From: Andrew Wood
Sent: 23 April 2019 09:55
To: Planning.Responses
Subject: LU/24/19/DOC : Windroos, Littlehampton
Attachments: 147.5001.400-B.pdf; 147.5001.401-B.pdf; 147.5001.402.pdf; 147.5001.403.pdf; Windroos Microdrainage updated calcs (18.04.19).zip

Substitute and additional plans.

1. Agreed below
2. Agreed below
3. All calculations are attached
4. Catchment areas provided as attached drawings 147.5001.402 and 403. Catchments and destination infiltration structures are colour coded. Catchment areas are also provided that have been used for the calculations.

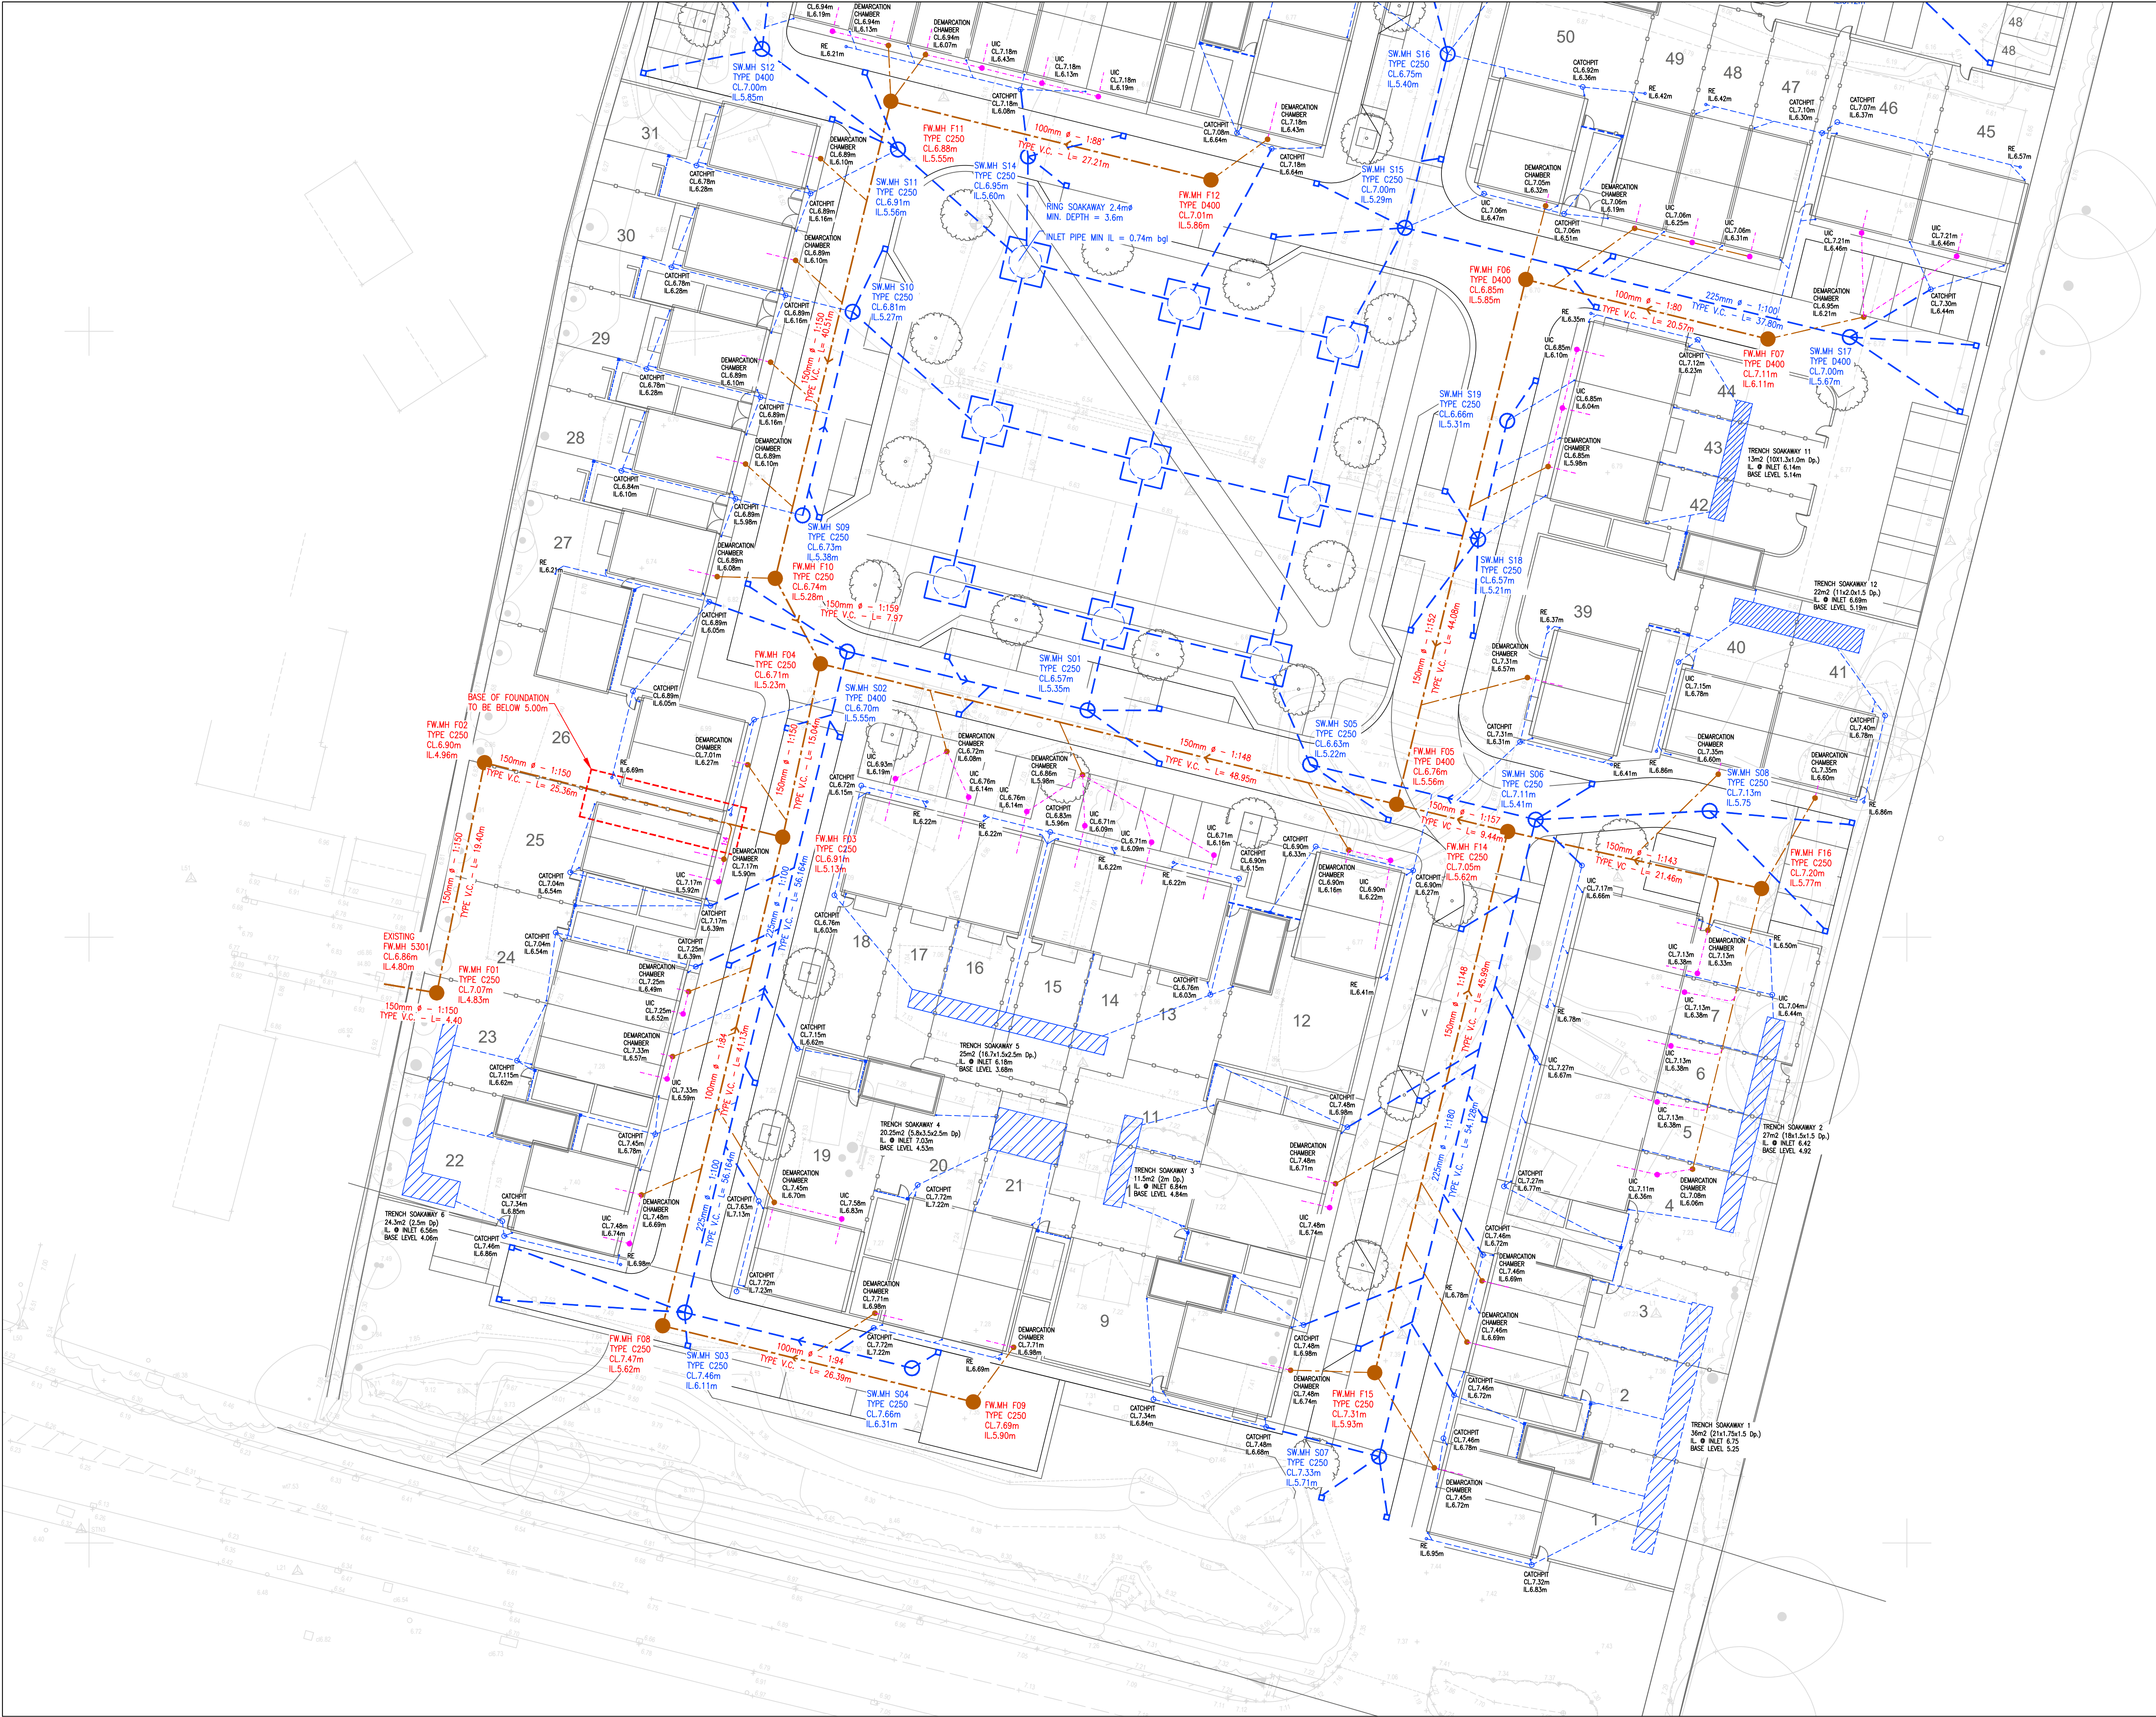
5. One of the sets of calculations provided does not seem to equate to anything proposed on paper. I.e. the modelled dimensions are not reflected on plan. All the calcs had a reference against the design but hopefully the provision of all of the gravel trench soakaways clears this up. *Please ensure that all calculation dimensions match up with those shown on plan. There are inconsistencies in:*
Northern soakaway
Trench soakaway 1
Trench soakaway 3
Trench soakaway 4

Please also ensure that modelled cover and invert levels match with those shown on plan.

5. Updated Microdrainage modelling calculations are attached. Each drained area total shown in 402/403 has had 10% added to allow for urban creep, which is the catchment area figure you will see in the outputs.

6. As mentioned below, the PCC soakaways for the southern catchment have been amended to the appropriate depth.
7. The strategy for the northern catchment has been updated. We have proposed 5 no. PCC ring soakaways in the vicinity of TP2 and the drainage system for the northern catchment all route to these. The infiltration rate from the ground investigation has been applied and the outputs attached show an appropriate half-drain time.

- Changing the ring soakaway size to 2.4mØ x 3.6m dp which addresses the comment from about suitability of the strata. This is adequate in terms of modelling which is also attached.
- Updating the trench soakaway references to have specific numbering which tie in with the attached modelling outputs from Microdrainage for them
